# CITY OF ALBUQUERQUE

3-19-24

**Re: Eagle Ranch Retail**  
**9641 Eagle Ranch Rd NW**  
**Site Plan**  
Architect's Stamp 3-5-24 (B13D002C)

Based upon the information provided in your submittal received 3-5-24, the above referenced plan cannot be approved for Building Permit until the following comments are addressed:

SHEET NUMBER
FIRE-1.0

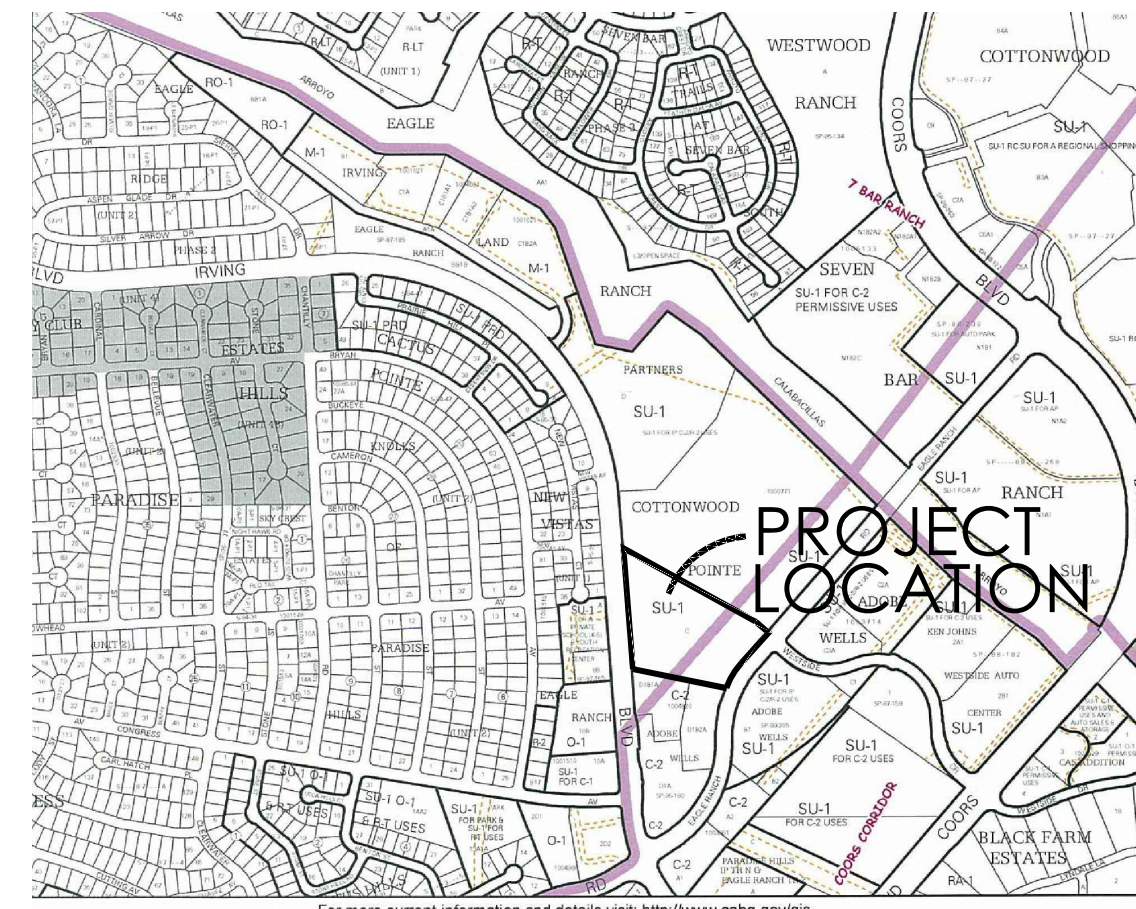
1. Complete the Traffic Scoping Form and send to Matt Grush. The site has two food service Drive Thru businesses.
2. Provide Solid Waste approval.
3. The approved Fire One plan, sealed 8-4-22, is considerably different than the AS-1.0 Site Plan, sealed 3-5-24. I prefer the functionality of the Fire One plan to be better.

- a. It has two drive lanes at the entry rather than three.
  - b. It does not have signage in the drive lanes.
  - c. It shows mini clear sight triangles at the entrance/exits to the project, however, they are drawn in the wrong location. They should be moved south to the back of sidewalk.

REVISION	DATE
RBA ARCHITECTURE, PC ARCHITECTURE PLANNING DESIGN 10000 N. 10th Ave. Ste. 200 Albuquerque, NM 87112 www.rba.com	
DATE	03-05-2024
SHEET NUMBER	AS-1.0

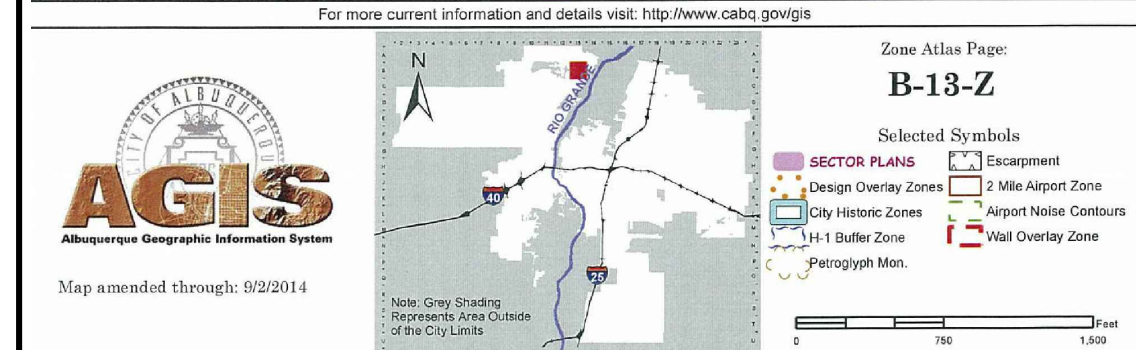
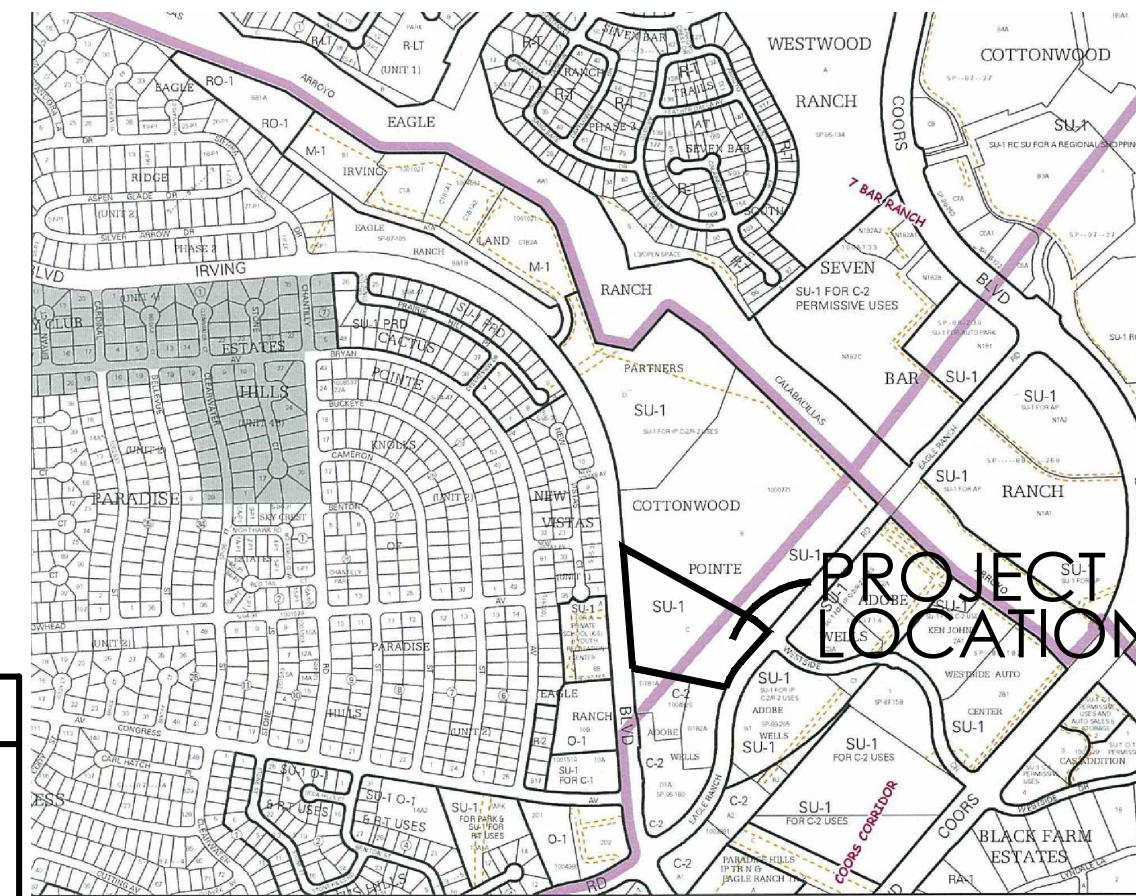
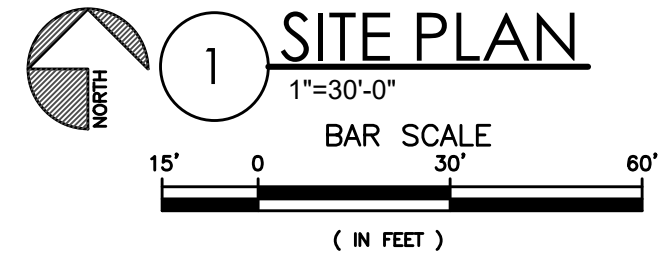
4. Please revise the Site Plan, AS-1.0, to look more like the Fire One plan.
5. The landscape buffer between the back of curb and the sidewalk along Eagle Ranch Rd. per the DPM is 5 to 6 feet wide. The City Standard Drawing is 2414.

6. Provide a detectable warning surface on the ramp on Eagle Ranch Rd
7. Drive thru lanes are a minimum of 12 feet wide with a minimum radius (inside) of 25". This radius may be reduced to 15' if the drive thru lane is increased to 14' wide.

8. Show the vehicle stacking. For Food Service, the minimum is 12 cars at 20' long for each car.
9. Show the streetlight in the Eagle Ranch Rd ROW.

10. Parking lot grades should not exceed 8% and major circulation aisles should not exceed 5%.
11. The minimum height to the bottom of an accessible sign is 60" not the 4'6" as shown in Detail A45 on Sht AS-2.0.

13. The Enclosure CMA Wall Detail, if used, should be revised to remove the bollard.
14. Change the ramp at the NW corner, on the west side of the entrance, to be a parallel ramp, rather than a corner ramp as the pedestrian path is only east-west.

15. Keyed Note 6. The Accessible aisle is to be striped blue, rather than white.
16. A few keyed notes state "per City of Albuquerque standards" or "per CABQ requirements". This is OK if followed by a City Specification: (e.g. 2415A), but not OK if the City Spec is not provided. Revise notes to only contain "Per CABQ ..." if the city Specification/drawing is provided, else provide a detail on the detail sheet.

- a. One example is Keyed Note 9: "Accessible parking signage per CABQ standards, REF: Detail A5-AS-2.0". Should be changed to: "Accessible parking signage per REF: Detail A5-AS-2.0" or similar.
